**PLAN REVIEW SHEET**

**Date: March 23, 2020**

**Petition #: RZP 2020-017**

**Address: Remount Road and Baltimore Avenue**

RZ-1

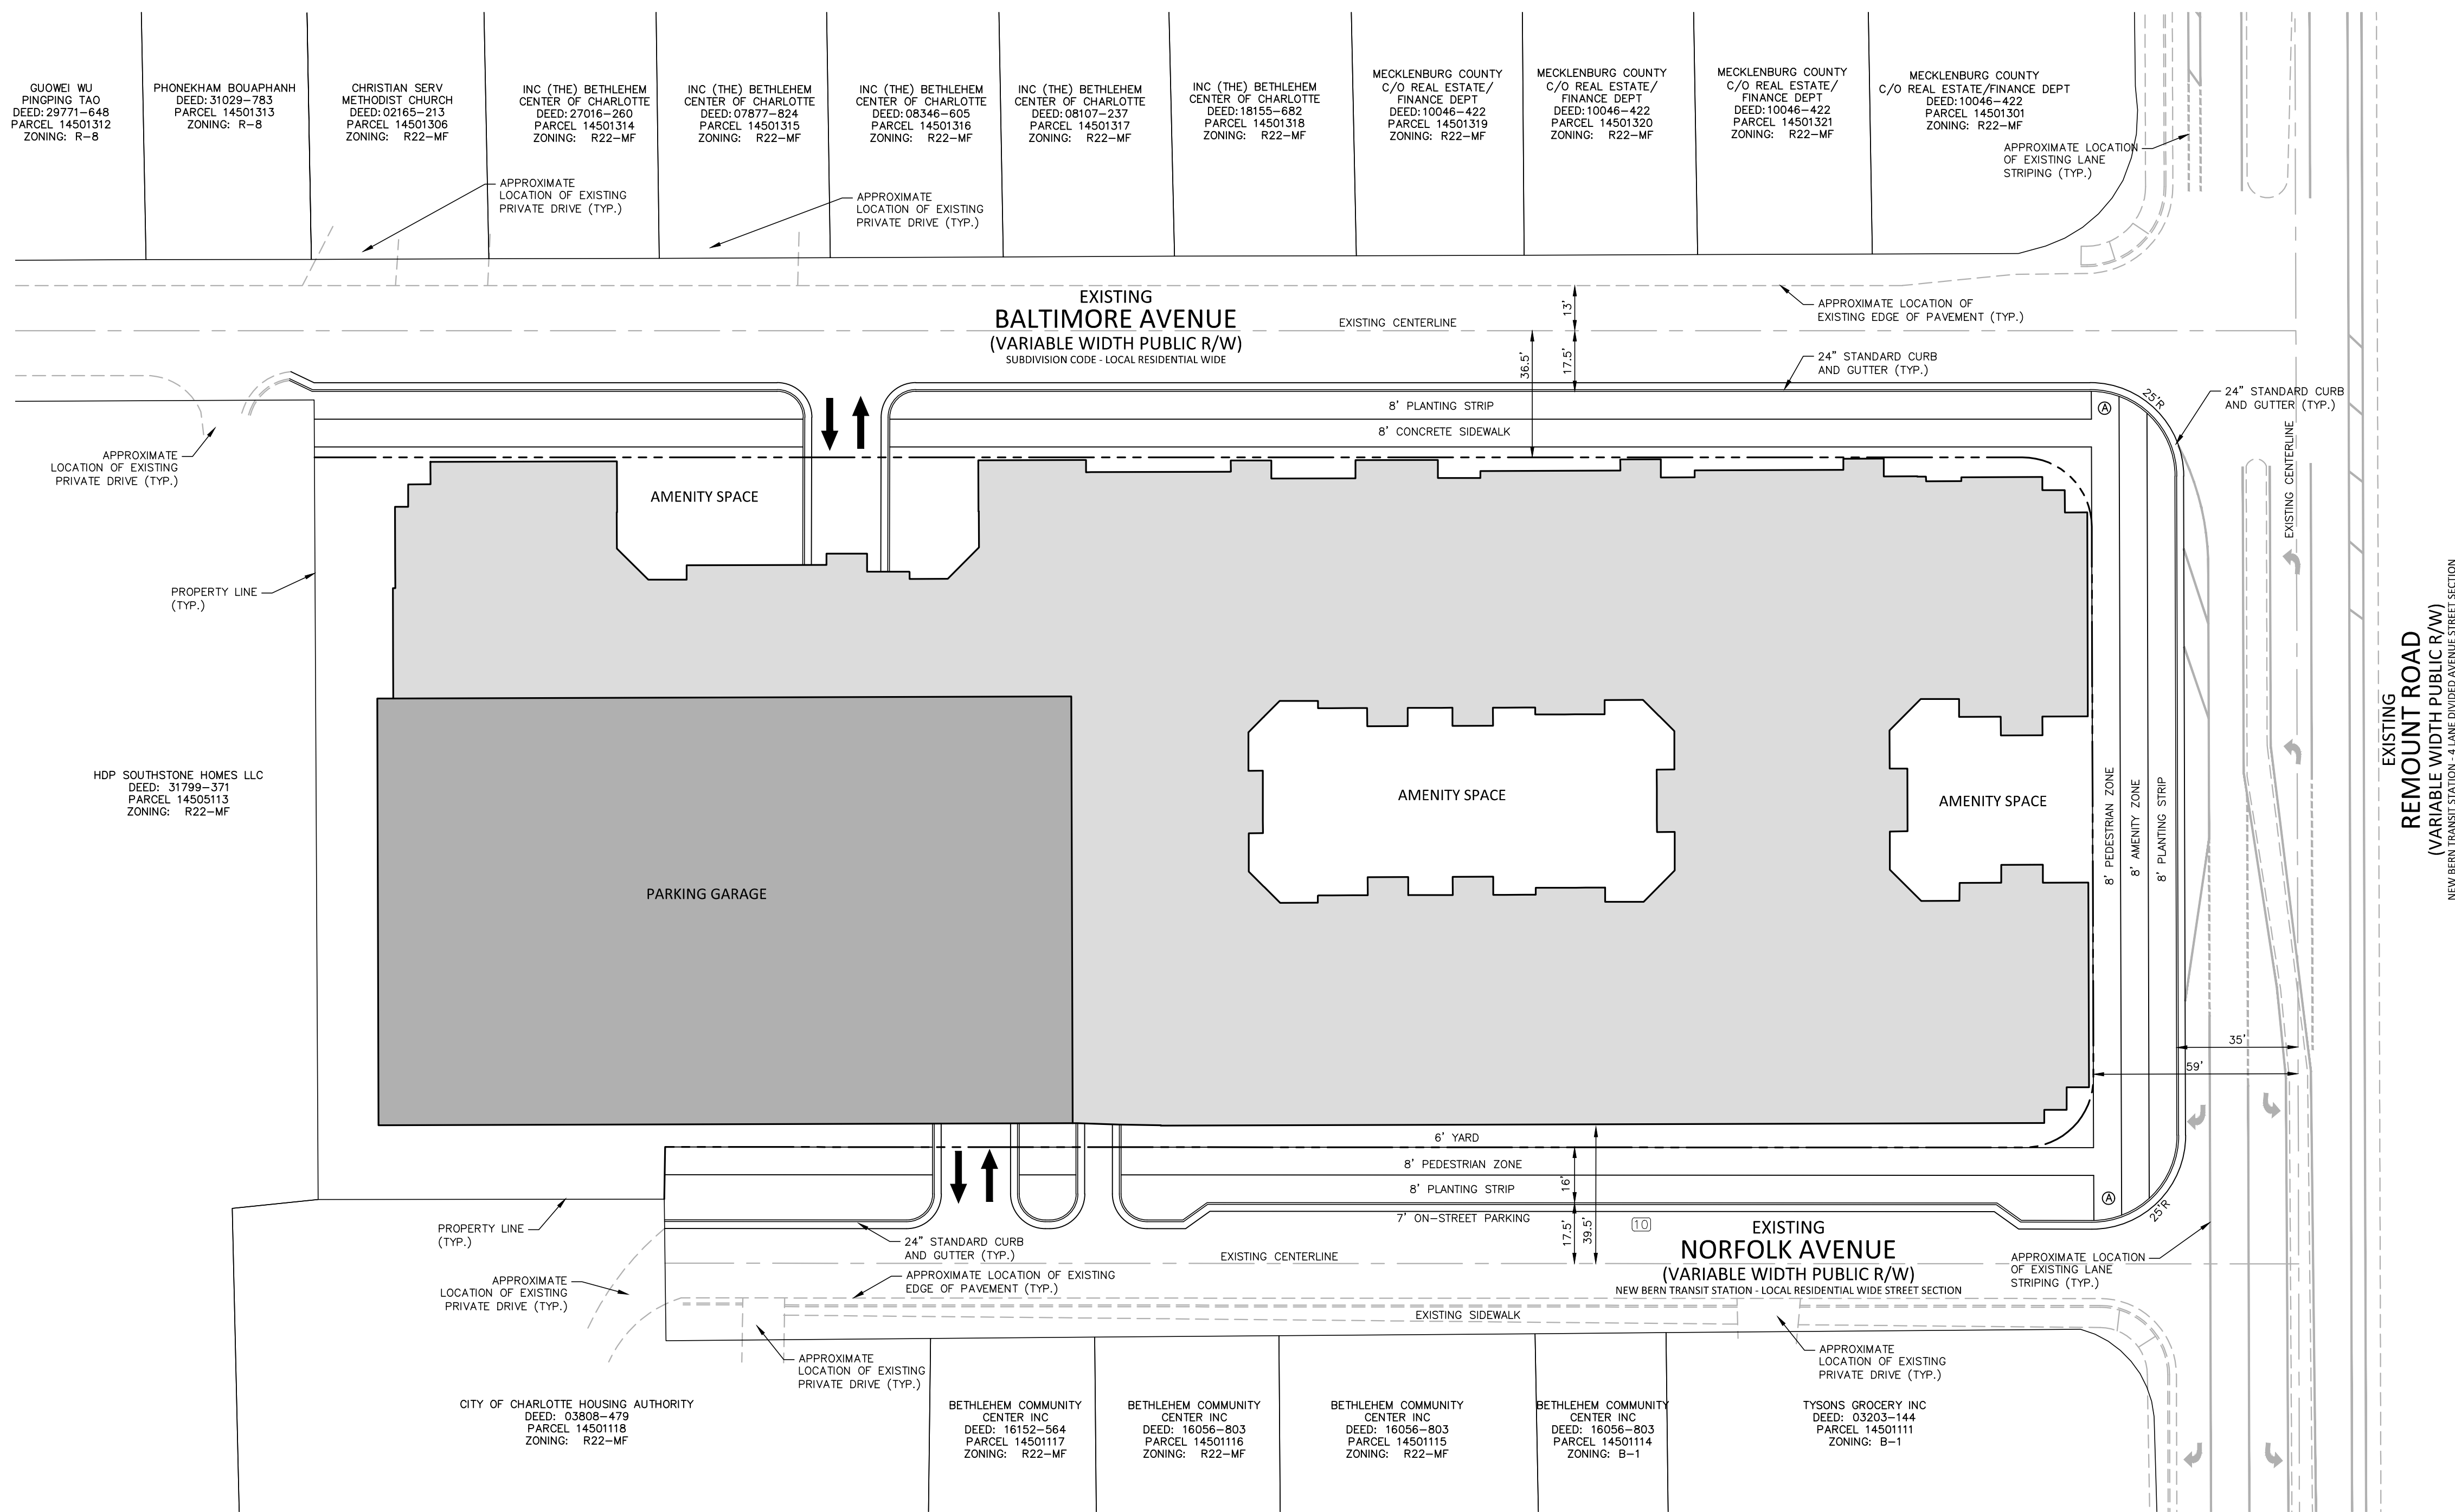
The site is located along CATS local bus route #2 on Remount Road, there is an existing bus stop and shelter in front of the Bethlehem Center. CATS requests the petitioner to reconstruct a new ADA compliant bus waiting pad and shelter per Land Development Standard #60.03A along Remount Road. Final location of the pad will be coordinated with the developer through the permitting process.
